From: Nick Hopper [REDACTED]
Sent: 06 February 2019 13:42
To: Simon Davis <Simon.Davis@arun.gov.uk>; Trish Paul [REDACTED]; Trish Paul [REDACTED]
Subject: Re: Highfield Rd BR/215/18/PL

Attached revised plans showing Flats 1 and 3 are now in adherence of minimum space standard requirements as we have removed the wall from the studies to show an open plan 1 bedroom layout (bedroom to 11.5msq); You'll recall this was something we spoke about last week as a possible solution. Good to see you are now in agreement that all other units are in adherence to Minimum space standards as our original submission and as annotated;

However, I have discussed this with our Group Head of Planning and although the national space standards do state that "Furnished layouts are not required to demonstrate compliance", we do not agree that this should be applied across the board and therefore, regardless of how the accommodation layout is shown (i.e. bed or desk), we should calculate the area requirements by size of room.

Ground Floor Plan (Proposed) @ 1:100

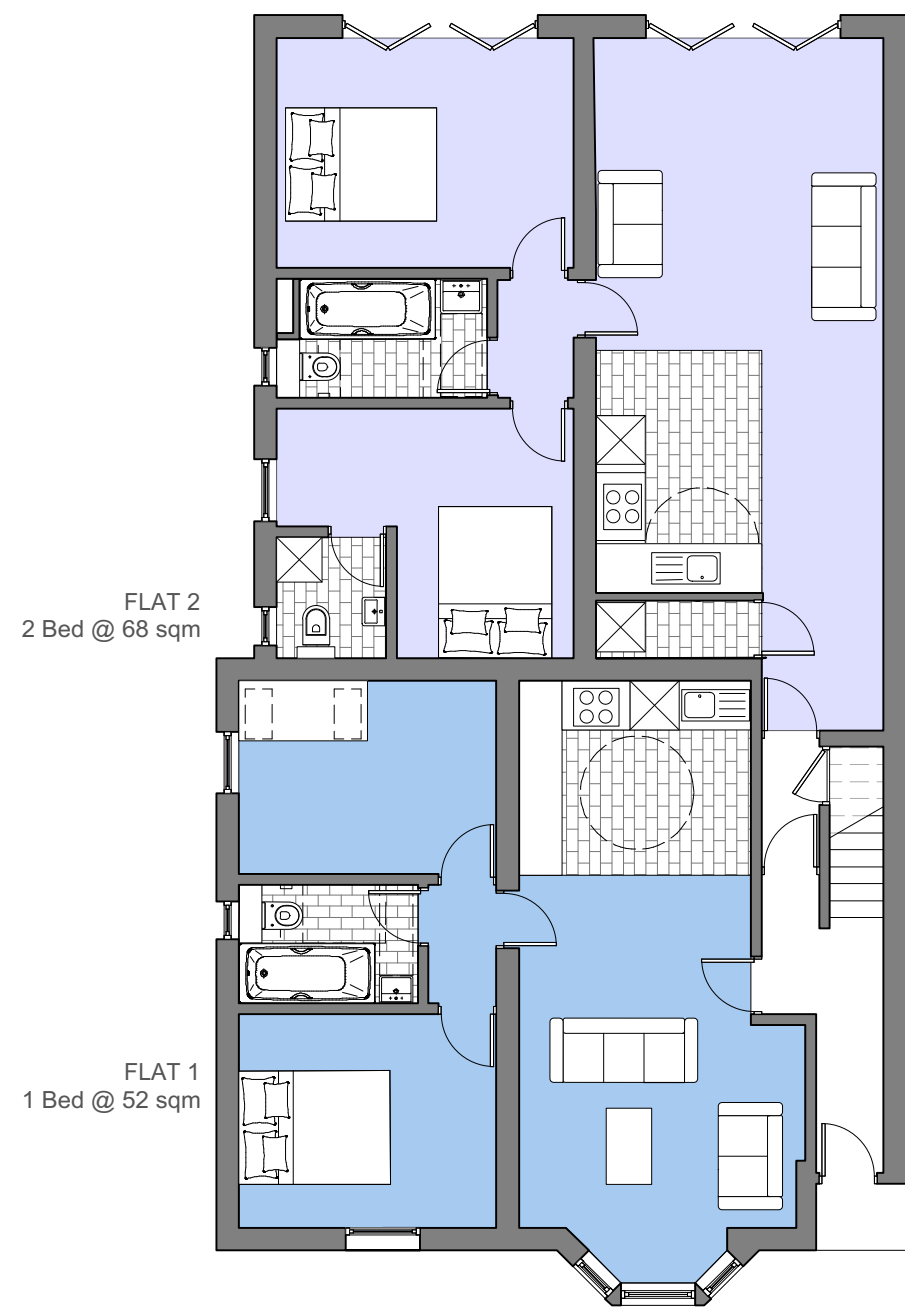
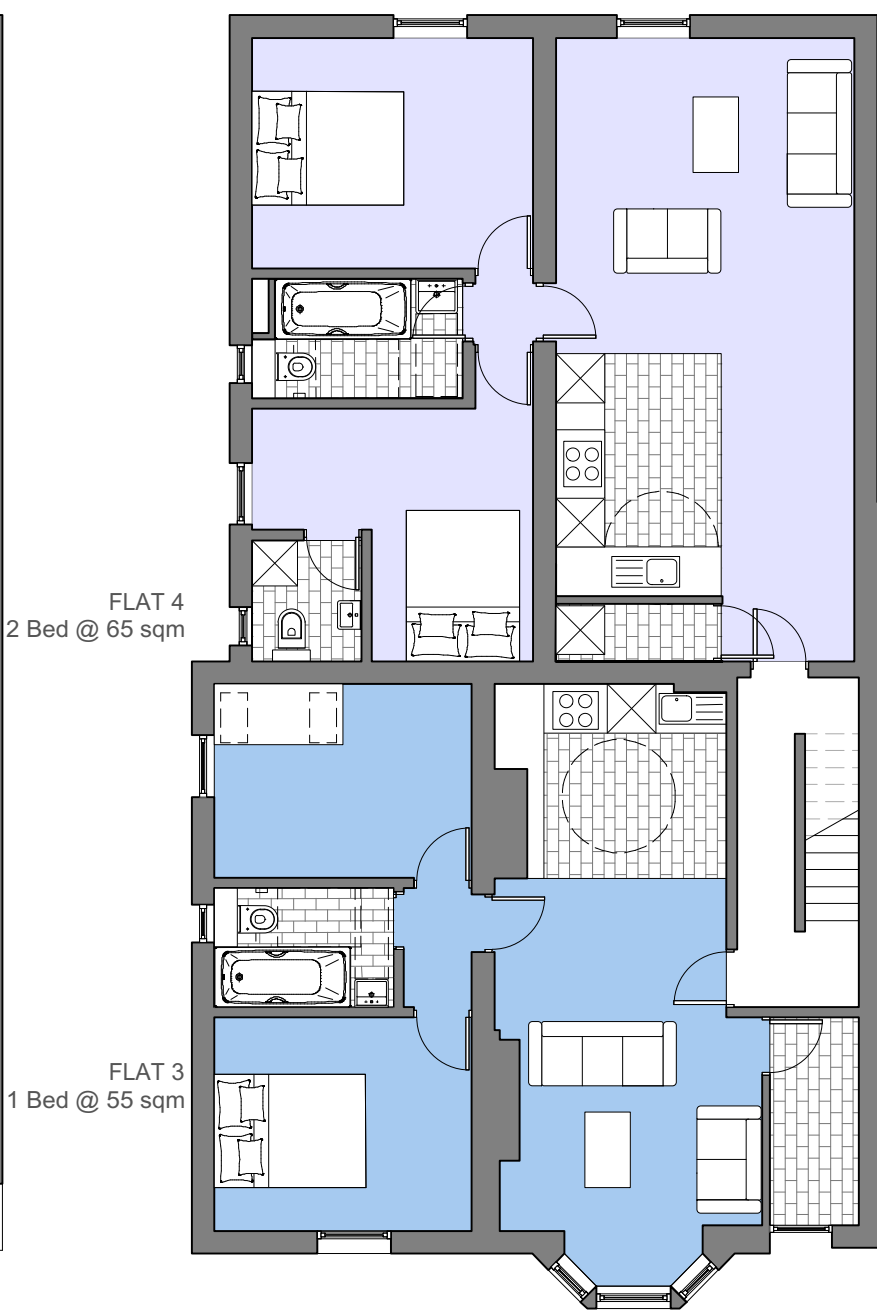
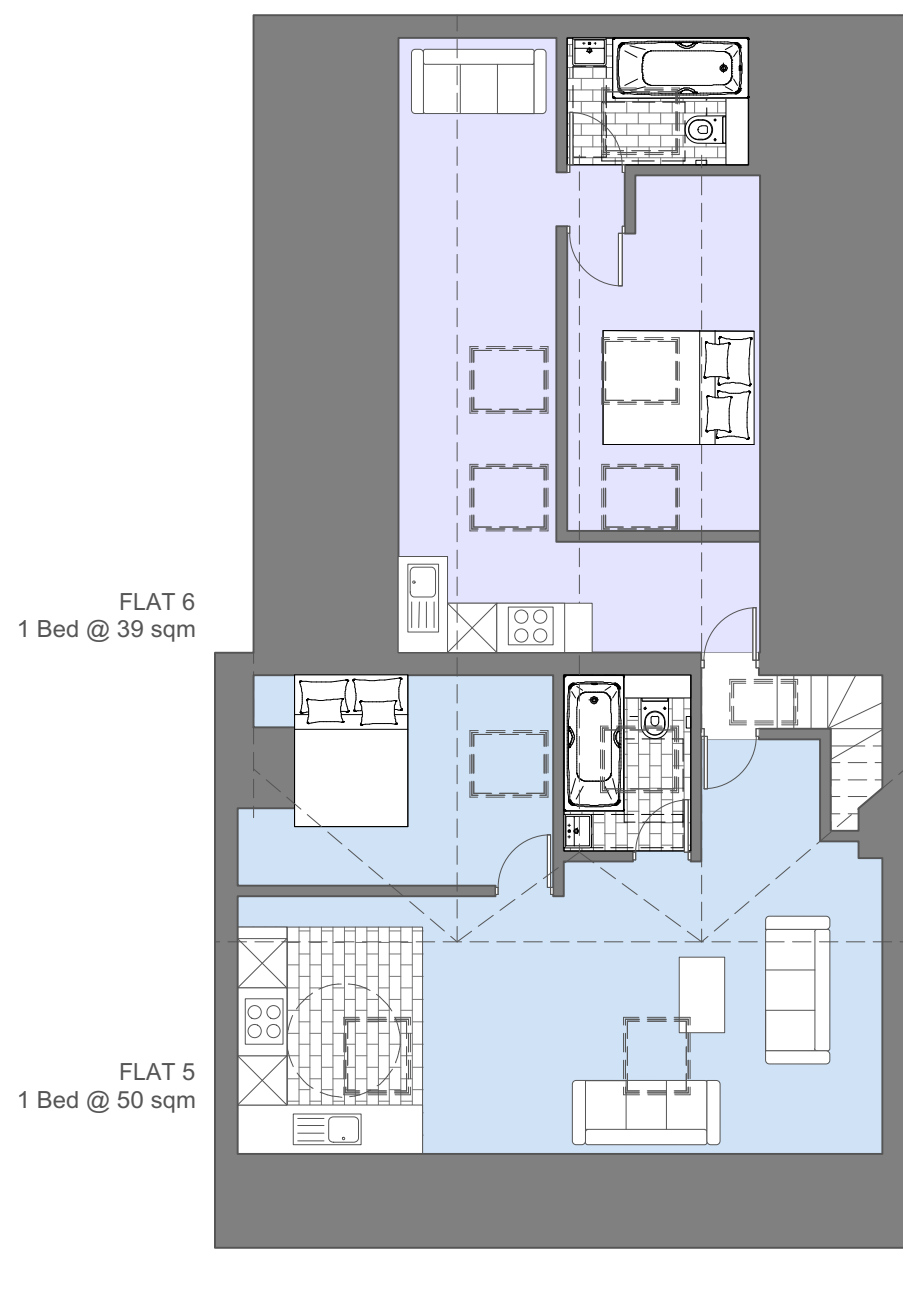
The standards say that a double is at least 11.5m² and a single at least 7.5m². I have therefore recalculated the requirements based on the size of the rooms and this means that now only 2 of the flats do not comply (see new table below). Clearly the two that do not comply are those that you suggest will be studies but we need to ensure that if the owner/occupier uses them as bedrooms then there is sufficient space elsewhere for their needs. We would be happy to defend this position on appeal.

Flat	No. Bedrooms	No. Persons	Requirement m ²	Proposed m ² (using your measurements)	Complies?
1	2	2	61	52	N
2	2	3	61	68	Y
3	2	2	61	55	N
4	2	2	61	65	Y
5	1	1	39	50	Y
6	1	1	39	39	Y

Many thanks for your time on Friday. As discussed please find attached revised plans indicating we have met minimum space standard requirements as annotated with the transference of single bedrooms to studies.
